Atlassian Office and Hotel Development (SSD-10405) – Response to Submissions

Attachment A: Items to be addressed prior to the determination of the proposed development

Figure 9 Proposed vehicle access arrangements

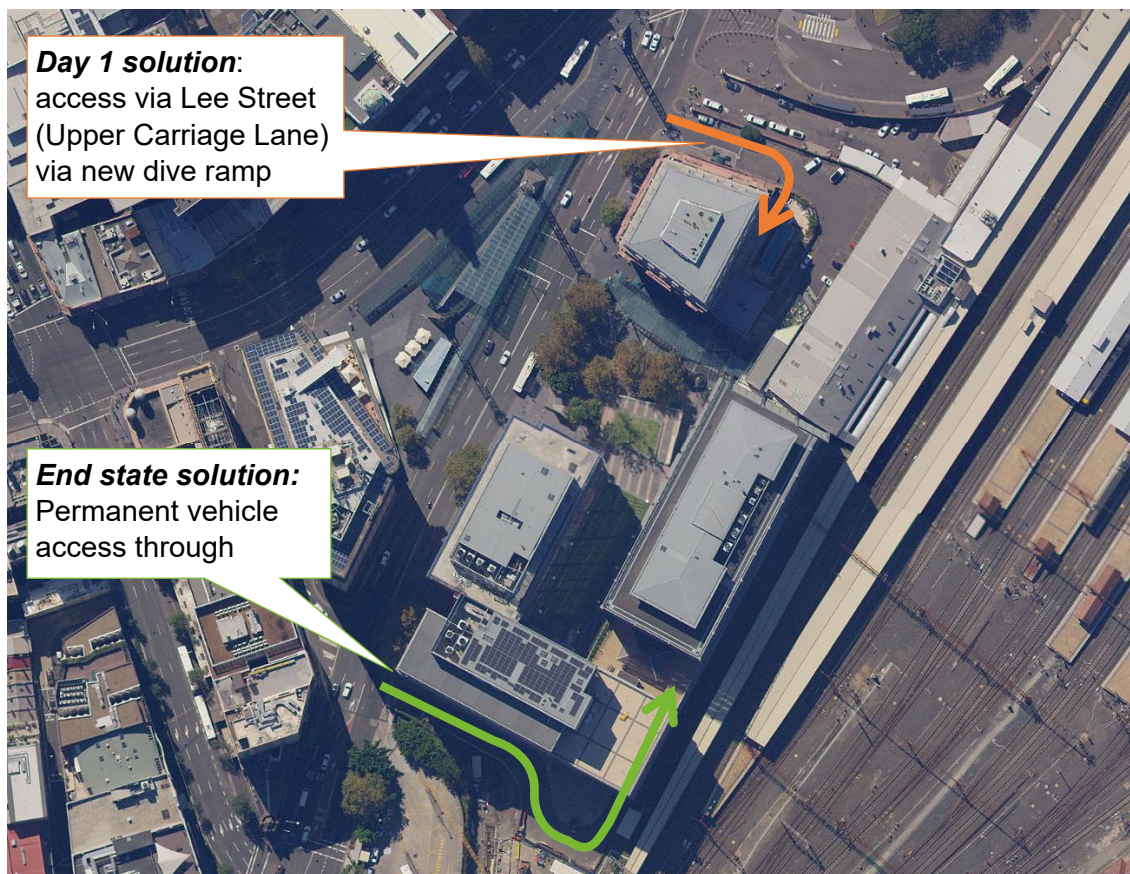
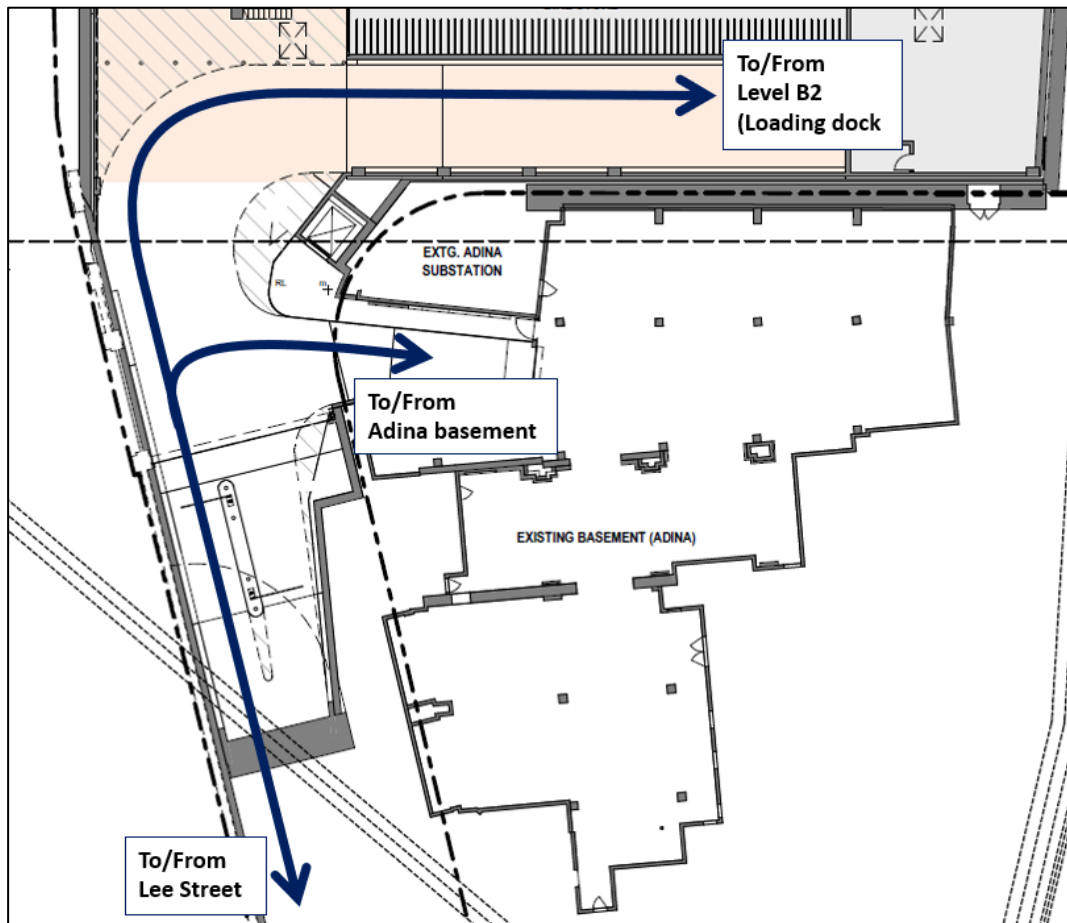
- The proposed Lee Street pick up and drop off area is part of the development proposal. Appendix E of the Traffic and Transport Response Report shows a total of six (6) pedestrian crashes including serious injury crashes in the last five years in the vicinity of the pick and drop off area as well as proposed access to the development;

- The traffic and pedestrian conflict is a concern due to the number of near misses observed along Lee Street and the fact that a significant number of pedestrians cross at midblock locations along Lee Street. The proposed arrangement is likely to increase conflict involving vehicles leaving the kerb and vehicles changing lanes just after the intersection and pedestrians crossing Lee Street at midblock locations. Any incidents on Lee Street would have potential to impact on general traffic and bus operation with the CBD and beyond; and

- A Stage 2 (Concept Plan) Road Safety Audit for the proposed Lee Street access arrangement, Lee Street pick and drop off arrangement and the proposed access arrangement in accordance with *Austroads Guide to Road Safety Part 6: Managing Road Safety Audits* and *Austroads Guide to Road Safety Part 6A: Implementing Road Safety Audits* by an independent TfNSW accredited road safety auditor; and
- Based on the results of the road safety audit, the design drawings needs to be reviewed to implement safety measures in consultation with TfNSW.
